**Byers Gill Solar
EN010139**

8.30 Applicant's Response to Rule 17 Request

Rule 17 Request - 20 December 2024

Drawing Title
**Figure 7.7.1
 Visual Receptors - Before Mitigation
 Matures**

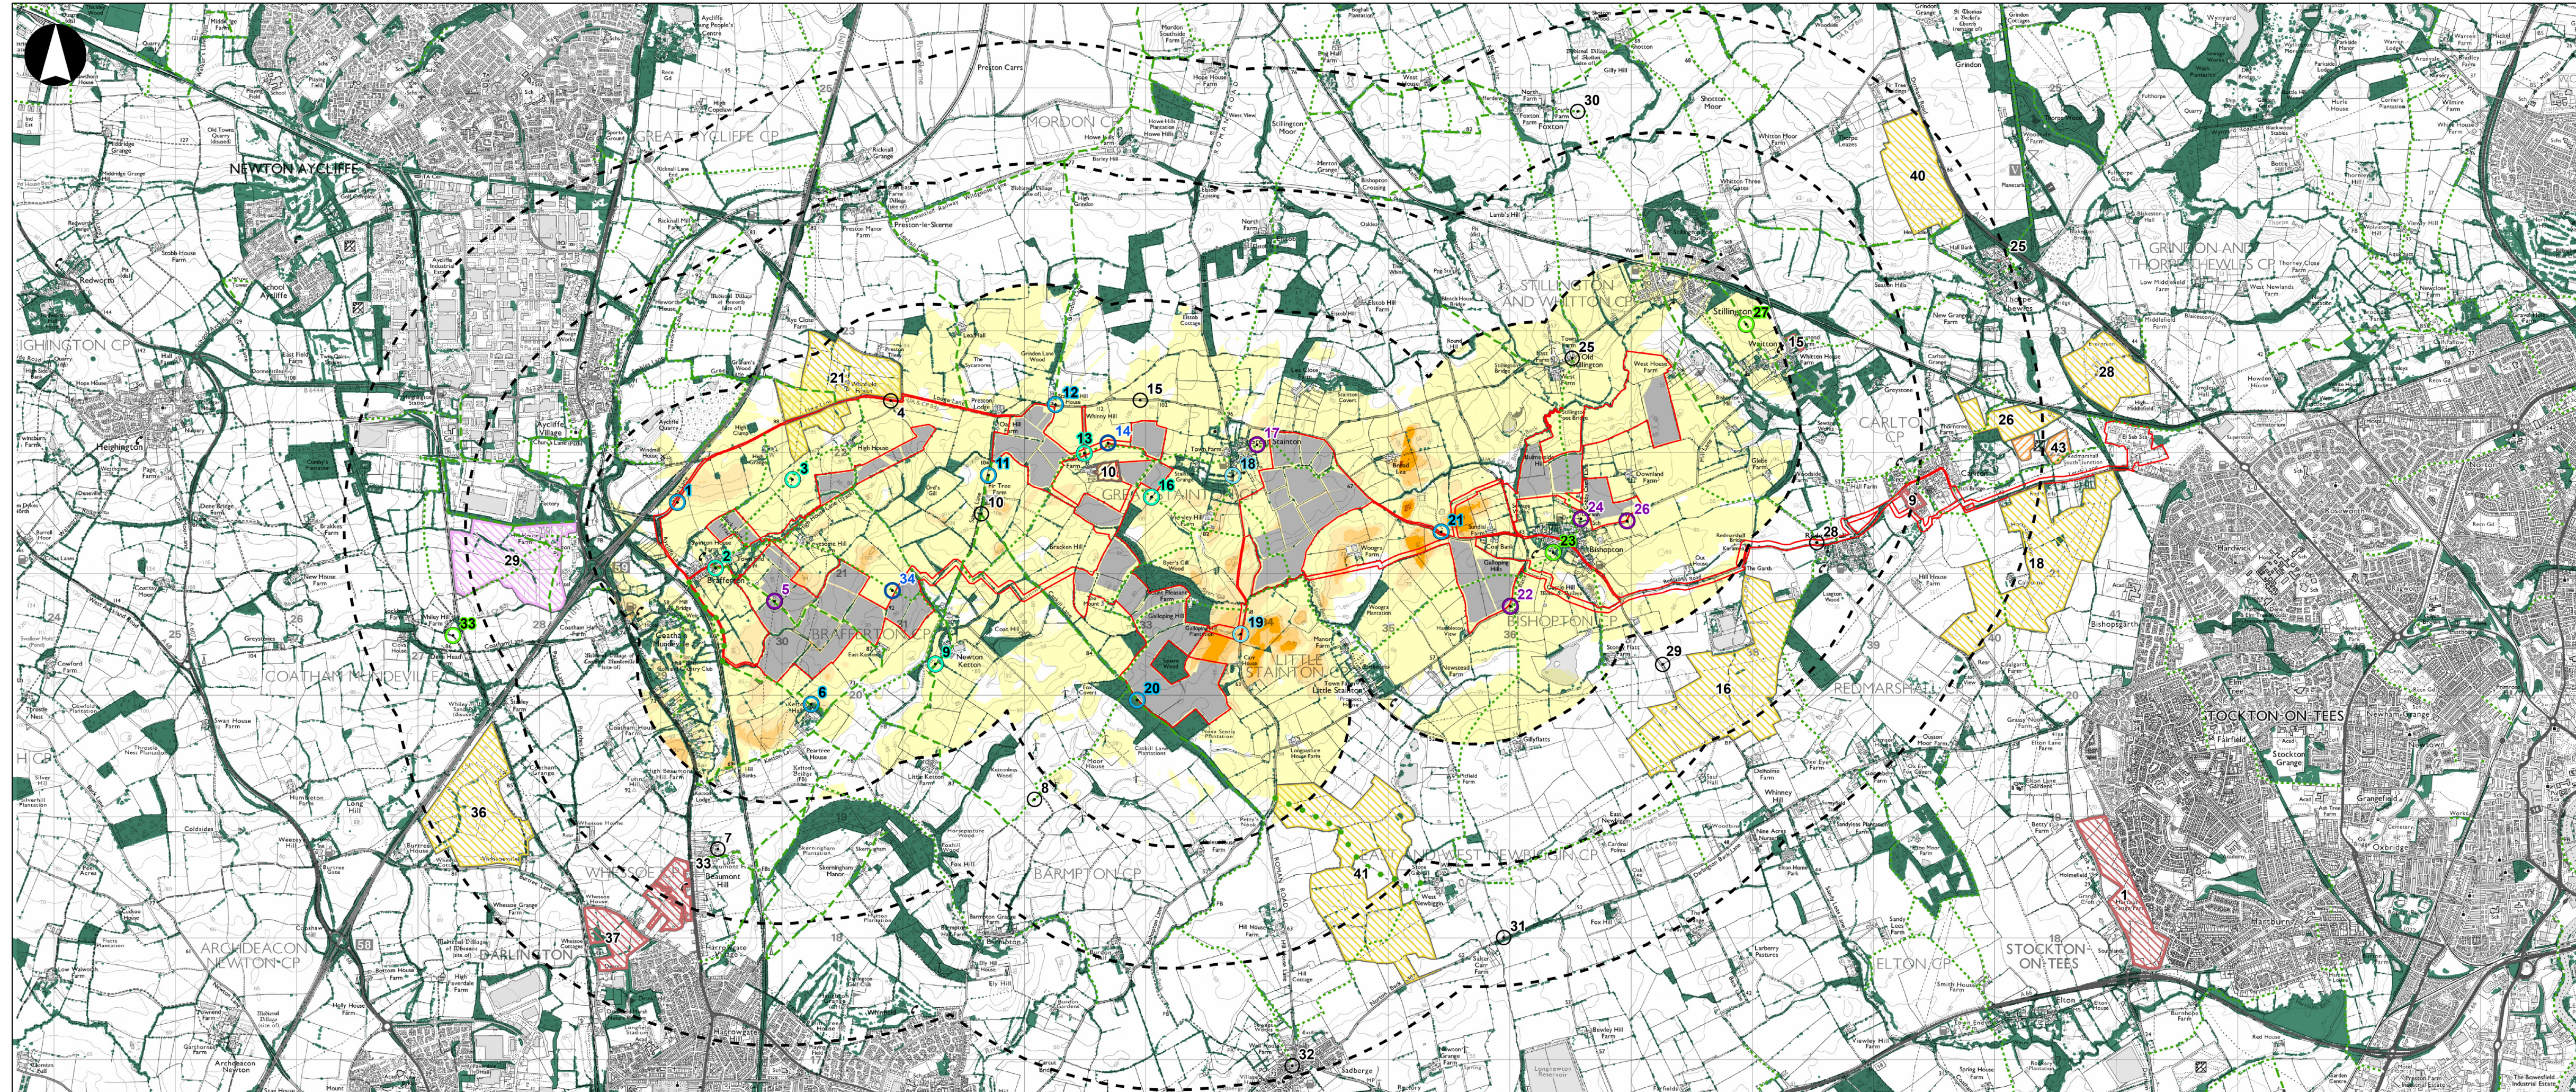
<p><i>By way of example, DBC referred to photograph V2 on page 9 of the Supplementary Information to the DBC LIR on Landscape and Visual Amenity [REP5-036]. The photograph clearly shows the visibility of Whinfield Solar Farm (under construction) from the public footpath between Brafferton and High House. Photograph V3 on page 10 of the Supplementary Information illustrates what DBC believes to be the worst-case winter views of the Application Site, where visible on land to the south-west of Lovesome Hill Farm (south of High House Lane). The photograph confirmed that this part of the solar farm would be visible in residual winter views from this footpath. DBC is unclear whether these worst-case views were taken into account by the Applicant in the ES visual assessment. Table 7-7 in ES Chapter 7 [APP-030] refers to Viewpoint 3 to assess the change in view from the section of footpath</i></p>	<p>Description and assessments of the scale of effect at DBC viewpoints V2 and V3 are provided in the revised ES Chapter 7 Landscape and Visual (Document Reference 6.2.7, Revision 2) and addendum to Appendix 7.4 Viewpoint Analysis (Document Reference 6.4.7.4, Revision 2) submitted in response to the Rule 17 request.</p> <p>As set out in the Applicant’s responses to ExQ2 LSV 2.6 [REP5-031], the visualisations, descriptions and assessments of scale of effect at viewpoints inform and illustrate the LVIA – they are not the assessment outcomes. The scale of effect at a viewpoint reflects the degree to which views would change <u>at that location</u> as a result of the Proposed Development – it does not reflect the scale of effect at other places. Similarly the description relates to that location, rather than other nearby places.</p> <p>As DBC note, the relevant assessment is provided at Table 7-8, however this is not an assessment of effects on ‘other parts’ of the footpaths as DBC suggest; it is the</p>

<p>“Table 7-8 in ES Chapter 7 describes the overall visual effect on the footpaths between Brafferton and High Grange/High House as large. This is due to the effect on views where the footpath will pass through the Application Site on a diverted route. There is no reference to the visibility to Whinfield Solar Farm in any of the descriptions in the ES and it is unclear if such effects have been taken into account. Even if this was the case, it is doubtful it would alter the assessment in Table 7-8 for these footpaths, given the scale of effect is judged to be large. However, this is not the key issue. The fact remains that potential cumulative effects have not been identified in the ES for this receptor. The descriptions in the ES would suggest that visual effects on this route would diminish as walkers travel further from Brafferton, when in fact, this isn’t the case if Whinfield Solar Farm is visible and becomes more visible towards High Grange/High House.”</p>	<p>As noted in the Applicant’s post-Hearing submissions for ISH7 Cumulative Effects Technical Note [REP6-021], Whinfield Solar Farm forms part of the future baseline. It is not the purpose of the ES to describe the effects of features included in the baseline, but to consider the effects of the Proposed Development. Considering the potential effects of the Proposed Development in the context of those features of the baseline (and future baseline) environment (in this case consented projects) ensures that they are taken into account as part of the LVIA. This is consistent with the guidance which is summarised at 1.3 of that Technical Note [REP6-021].</p> <p>Both of the footpaths between Brafferton and High Grange/High House pass close to Whinfield solar farm as they continue north and northeast away from Brafferton and are likely to have some visibility of Whinfield solar farm. Viewpoint 3 provides an example of a location where there are also notable views of the Proposed Development – effectively representing a ‘worst case’ for combined views of both solar farms. The more nearby visible presence of Whinfield solar farm and reduced visibility of the Proposed Development as the routes continue north and northeast from viewpoint 3 would mean that the Proposed Development would give rise to a reduced change to the views (i.e. less than Small scale), and does not warrant detailed description in considering the likely significant effects of the Proposed Development.</p>

Extract from REP6-033	RWE response
<p>beyond the Application Site. The scale of effect at Viewpoint 3 is judged to be small/adverse. The viewpoint is referenced in Table 7-8 to describe the effects on other parts of the footpaths between Brafferton and High Grange/High House. However, there is no descriptive text for Viewpoint 3 which refers to the visibility of Whinfield Solar Farm, the change in view of Brafferton village or the long term visibility of solar panels on part of the Application Site, south of High House Lane.”</p>	<p>assessment of effects on users of the footpaths, including at viewpoint 3. Table 7-8 identifies effects on both of the footpaths between Brafferton, High House Farm and High Grange as receiving Large scale effects – clearly describing and assessing effects as being greater than the Small scale effects experienced at Viewpoint 3 – i.e. regardless of what viewpoint is illustrated, the assessment takes account of the maximum scale of change for users of each route.</p> <p>Visibility of Whinfield Solar Farm is set out in the viewpoint description for viewpoint 3, at the end of the baseline description (‘existing views’ column) in Appendix 7-4 [APP-135 and clearly illustrated by visualisations for view 3a looking north from viewpoint 3 [APP-071]. Views to Brafferton are not described as the village is not a notable part of the view from viewpoint 3 – as illustrated by the photograph for view 3c looking west from viewpoint 3 [APP-071]. The solar panels south of High House lane are included in the description of changes to the view from viewpoint 3 in Appendix 7-4 [APP-135] as being located “in fields to the southwest seen beyond and amongst intervening vegetation.”</p>
